From: Sarah Burrow <Sarah.Burrow@arun.gov.uk>
Sent: 18 February 2020 09:38
To: Planning.Responses <Planning.Responses@arun.gov.uk>
Cc: Maria Tomalova <Maria.Tomalova@arun.gov.uk>
Subject: RE: Planning Consultation on AL/9/20/DOC

Engineers Comments Regarding Surface Water Drainage

APPLICATION NO: AL/9/20/DOC

Description of Works: Approval of details reserved by condition imposed under ref
AL/70/19/PL relating to Condition No 4 - surface water drainage

Site and Location Plan
Scale at 1:100 in meters
0 5 9

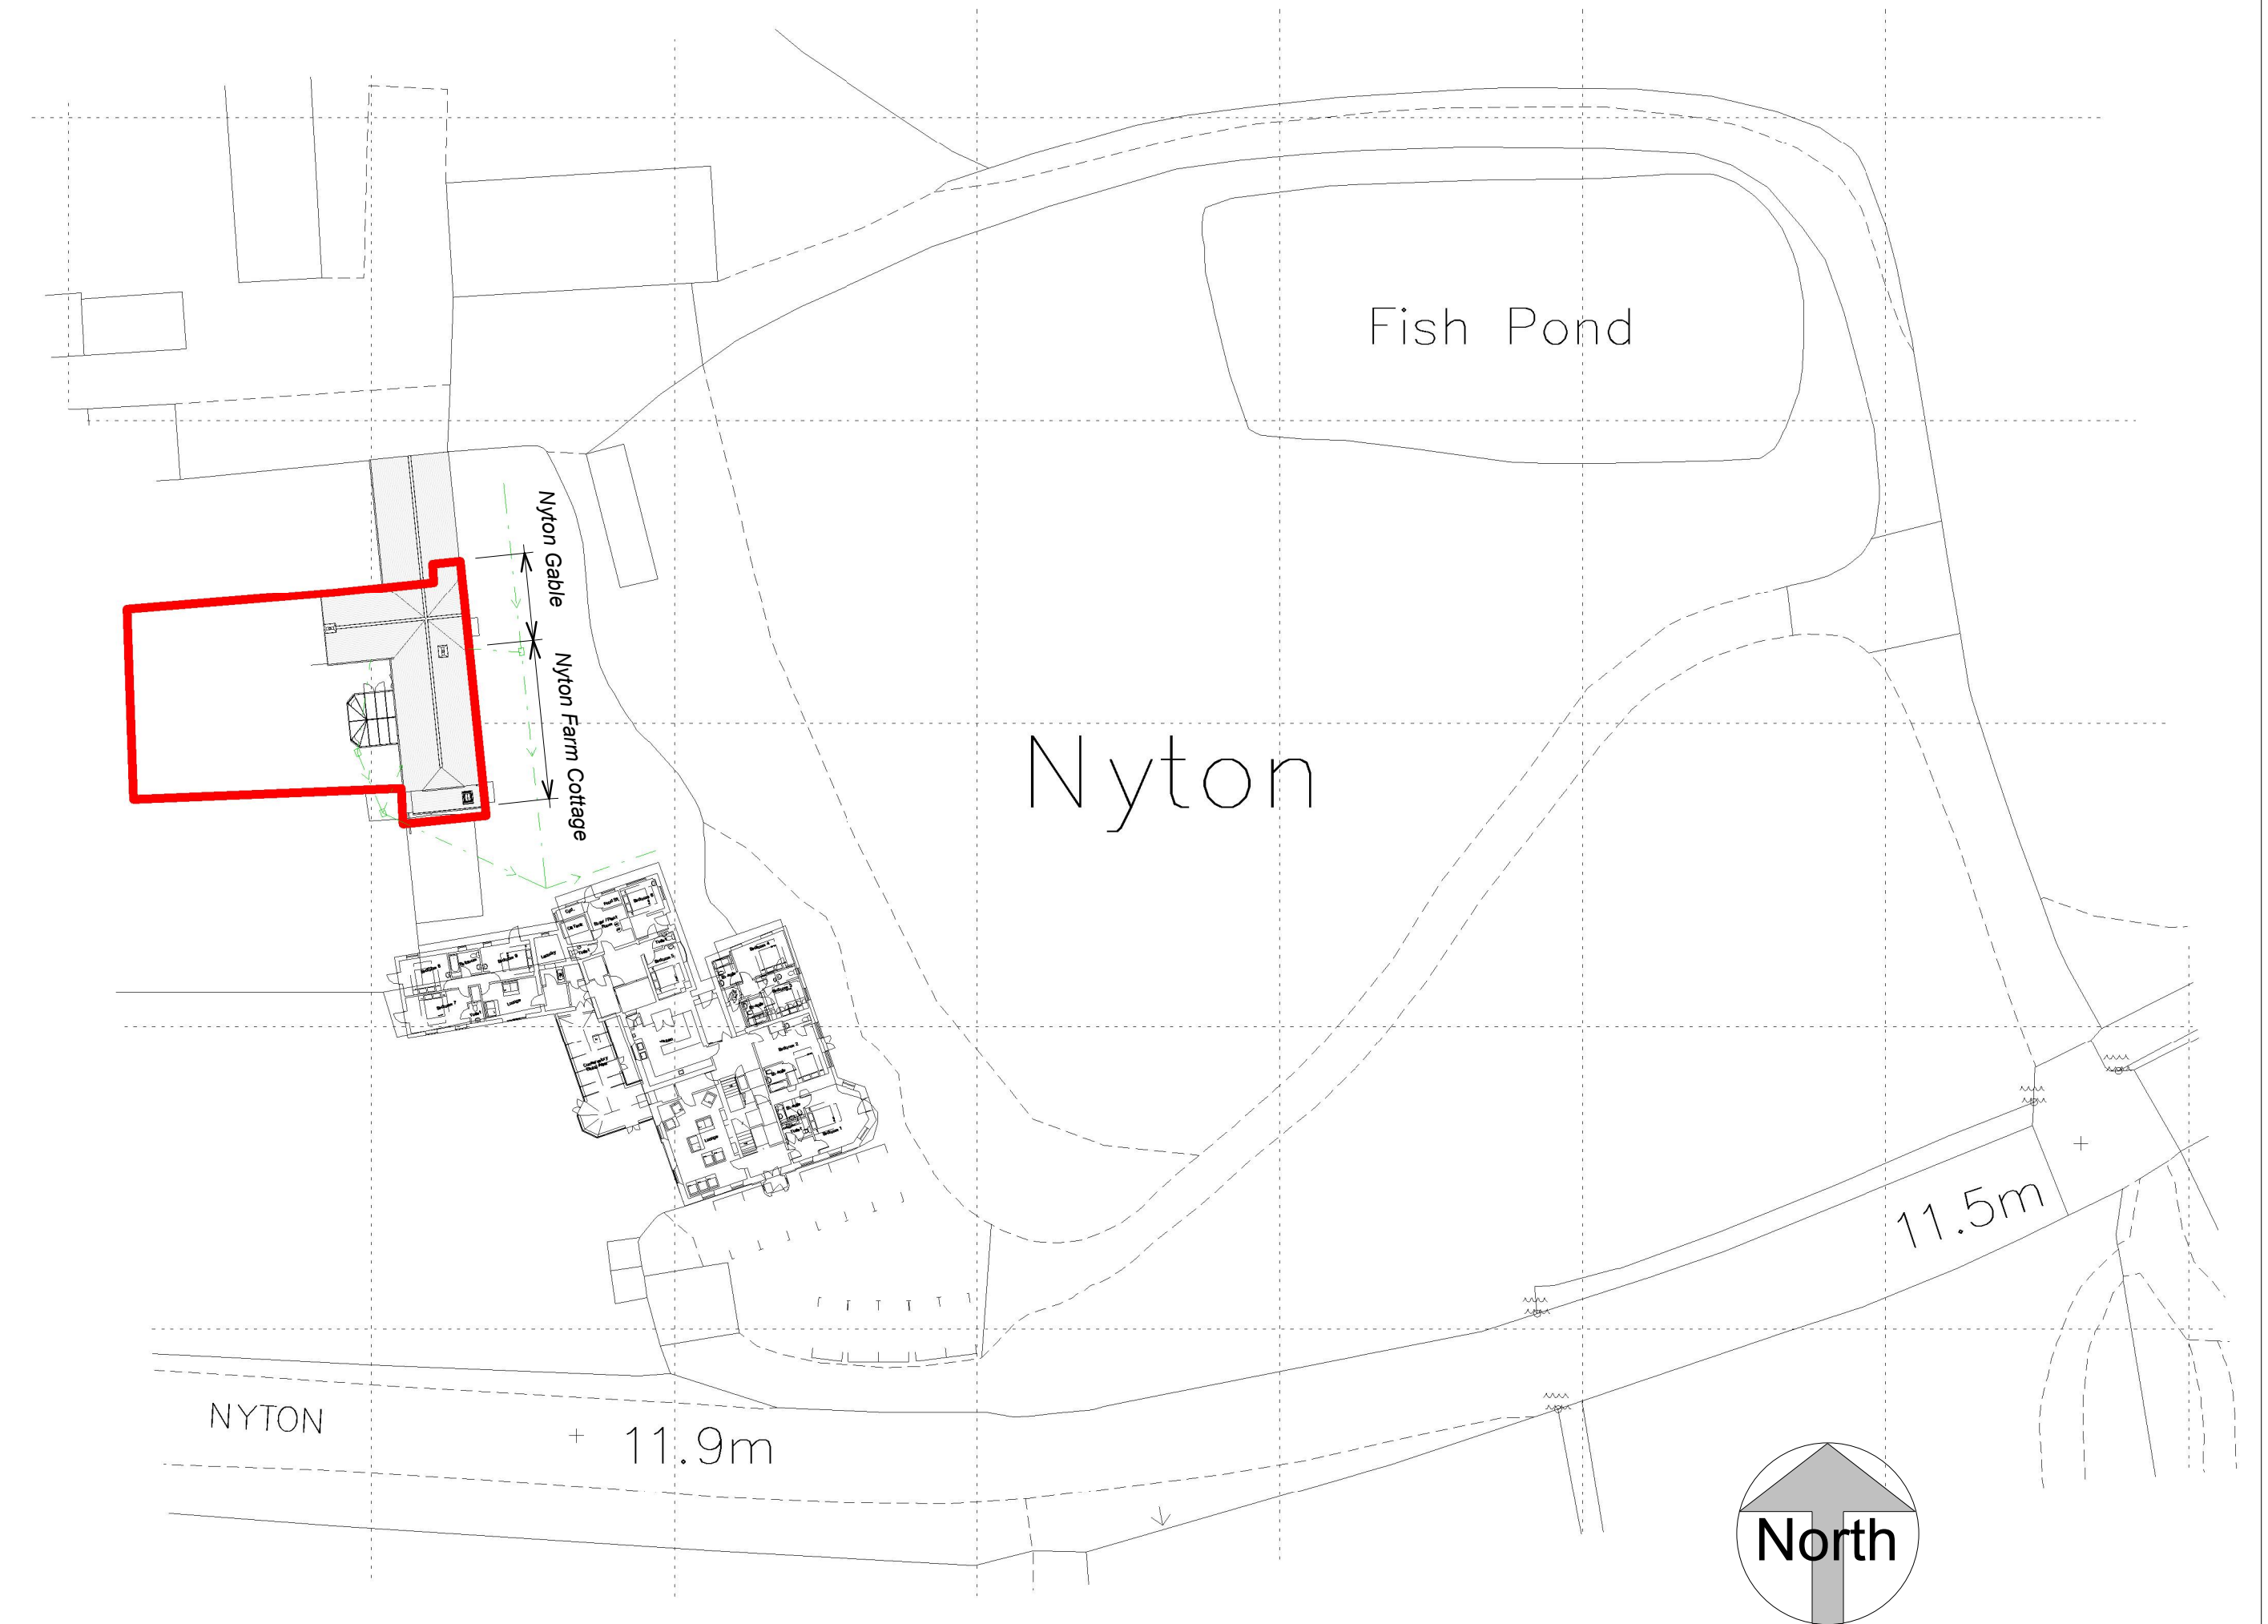
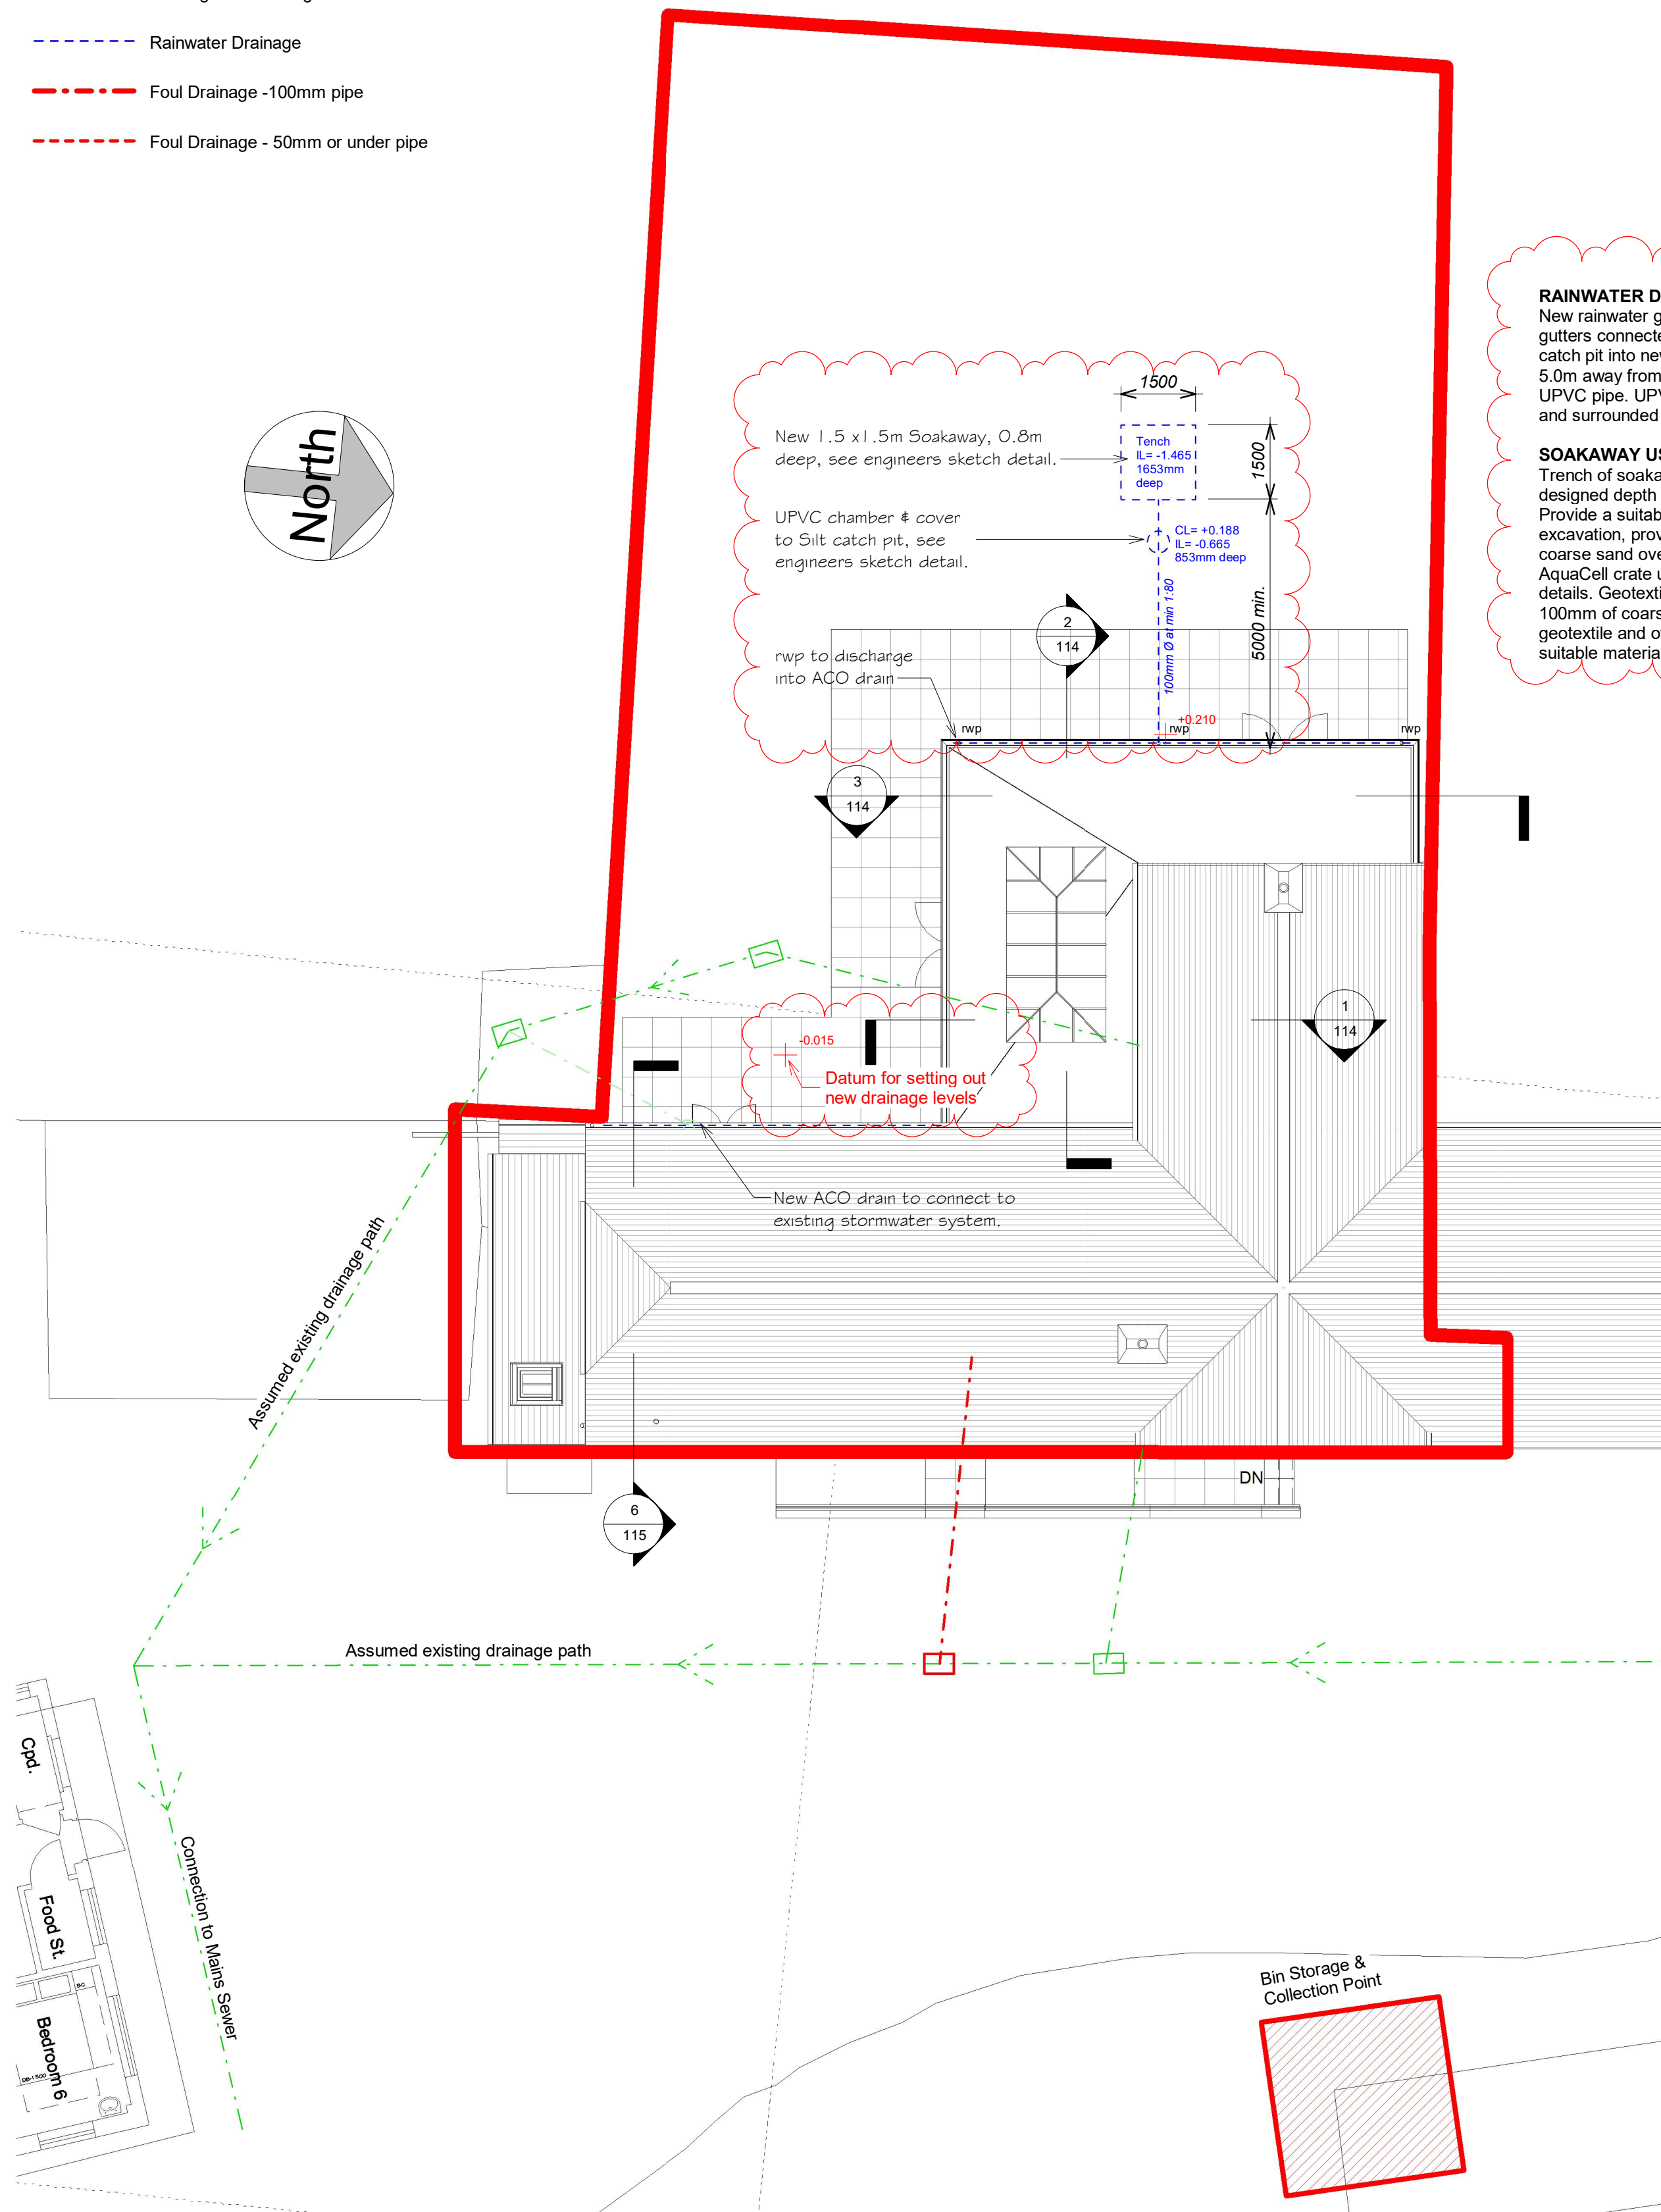
For future reference the agent should note that we normally expect a construction detail drawing for pipe bed and surround, however in this case, due to the scale of the development the noted specification is adequate. On any future applications a drawing will be expected.
